**RE: FIRST SECURITY BANK - COTTONWOOD (B13-D13). GRADING PLAN FOR  
BUILDING PERMIT APPROVAL. ENGINEER'S STAMP DATED 16-16-96.**

Based on the information provided on your October 16, 1996  
submittal, the above referenced project is approved for Foundation  
Permit only. Prior to Building Permit approval, please address the  
following comments:

FIRST SECURITY BANK - COTTONWOOD
GRADING & DRAINAGE PLAN

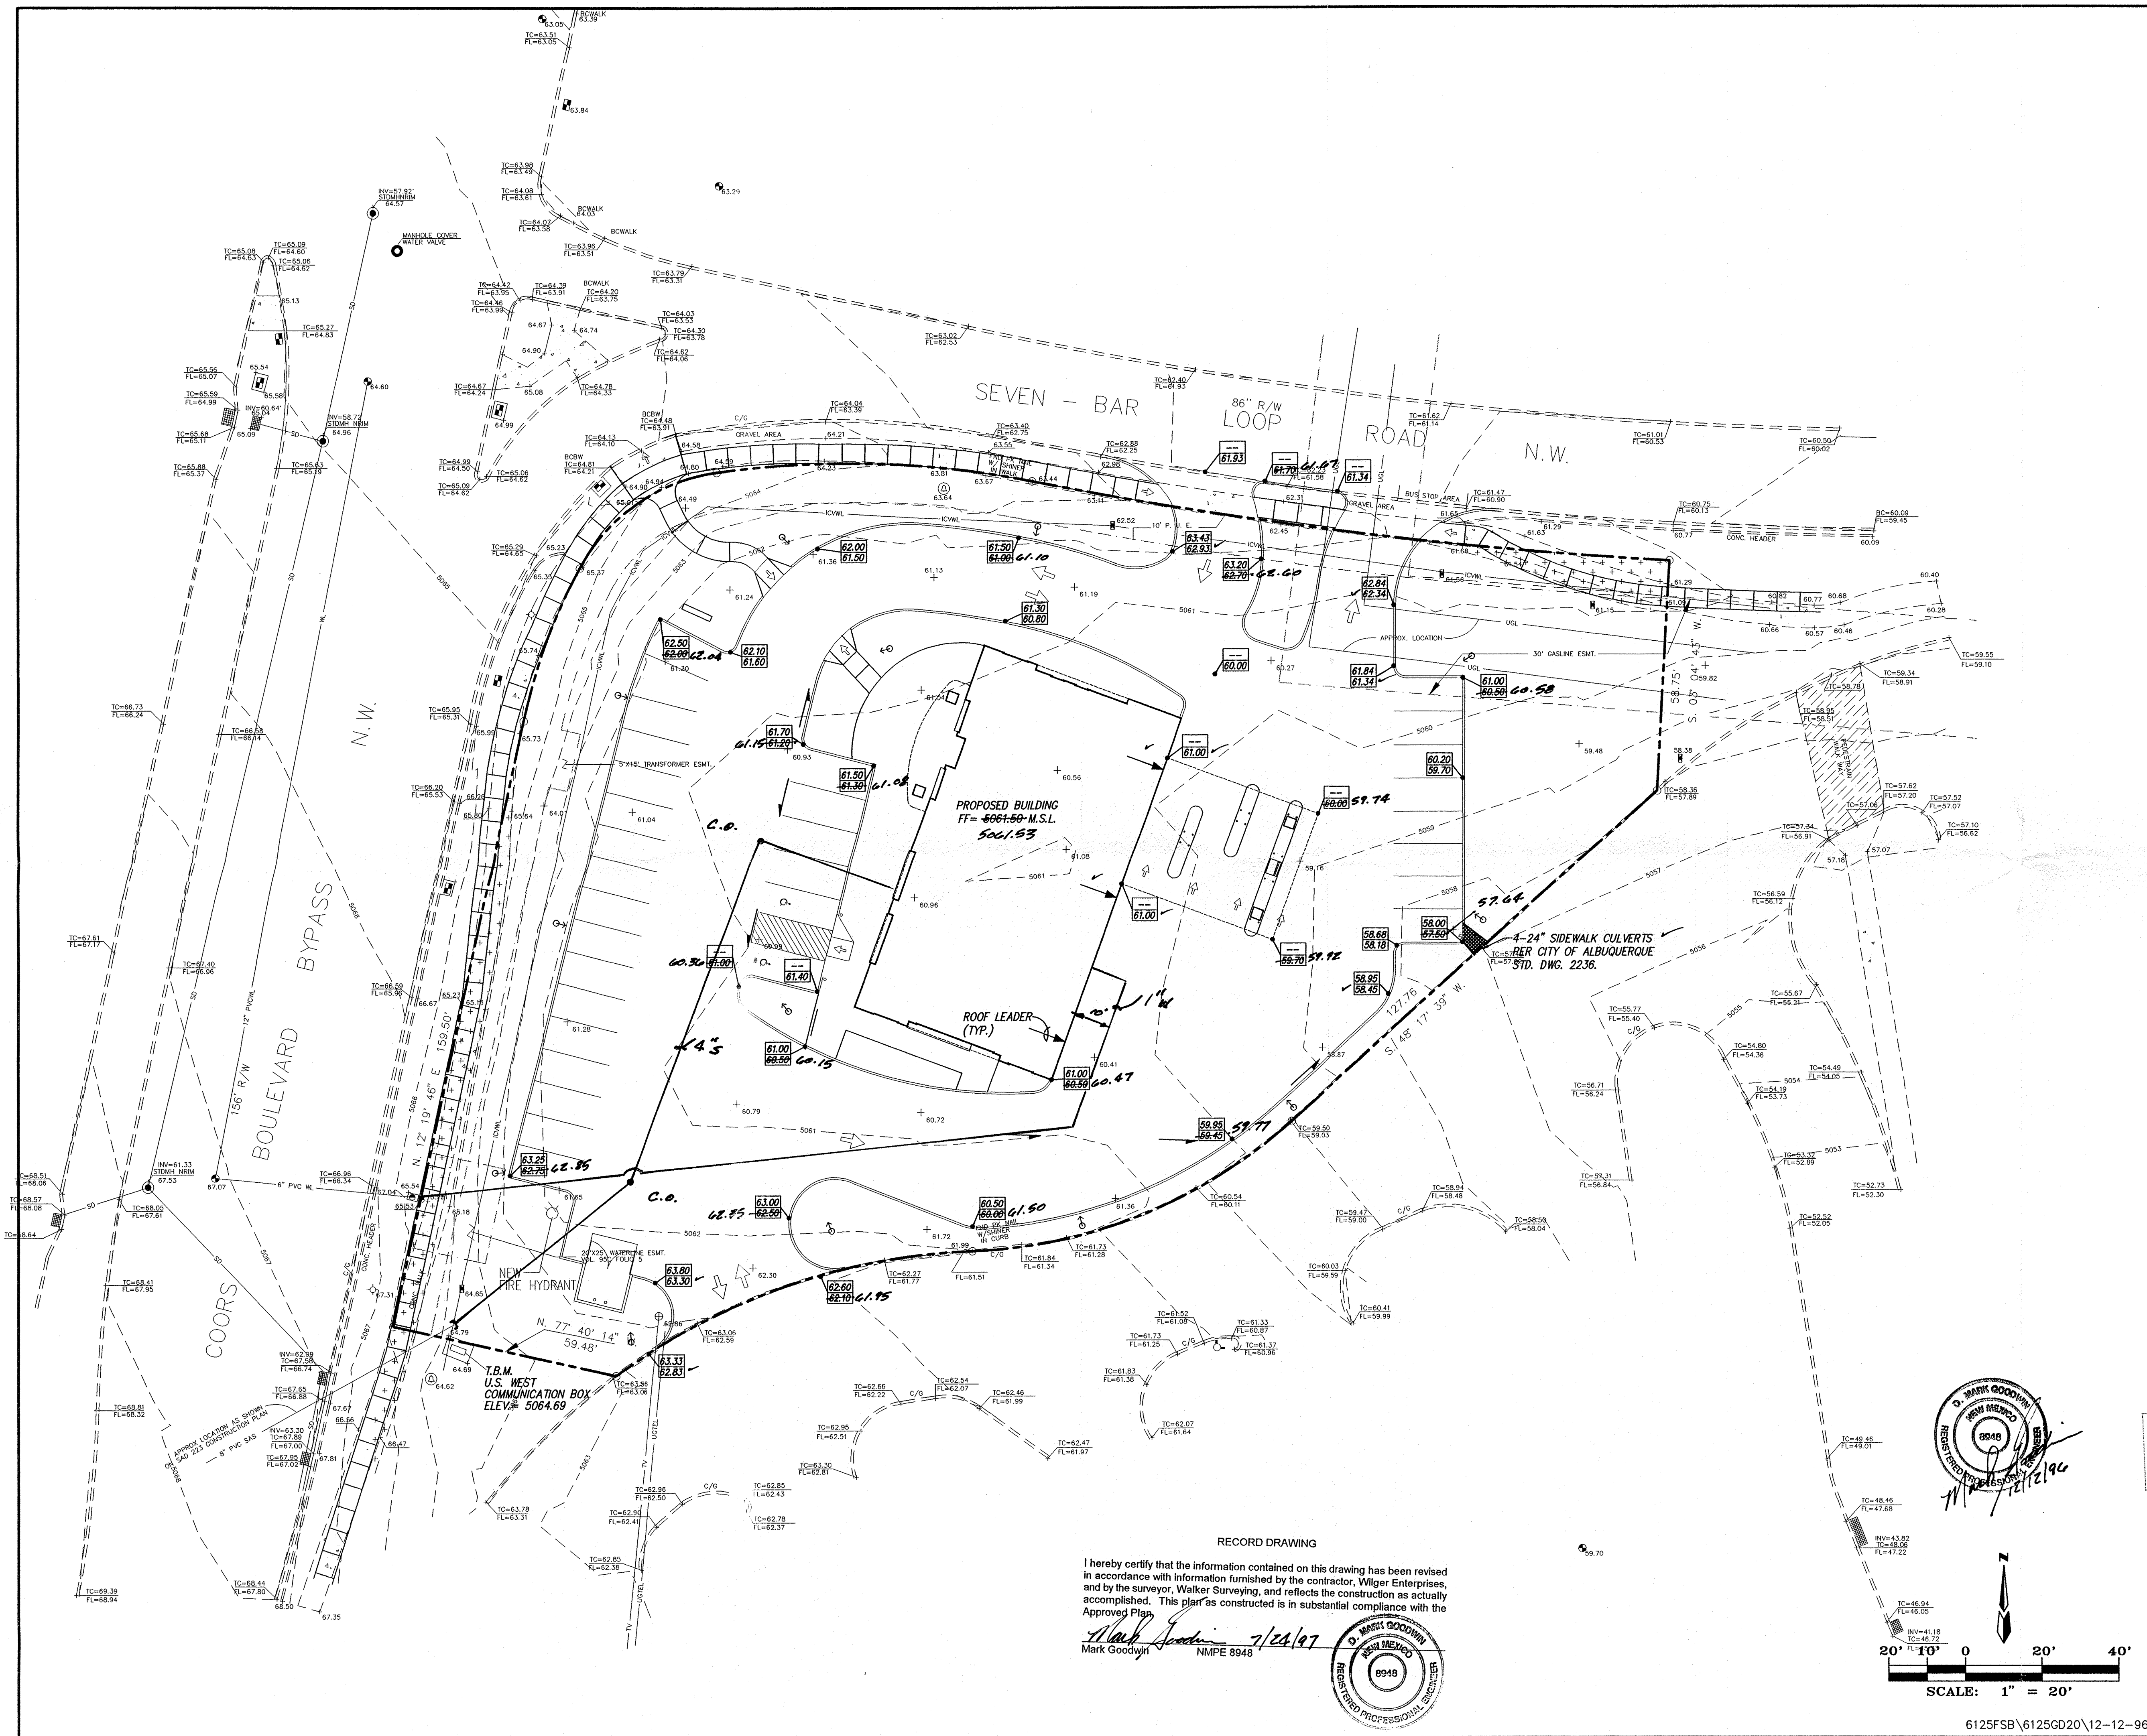
1. Provide appropriate excerpts from the Cottonwood Mall  
Master Plan addressing free discharge from this site.  
What is the discharge from this site?
2. Please provide a detail for the 5-foot sidewalk culvert.
3. A cross lot drainage easement will be required.
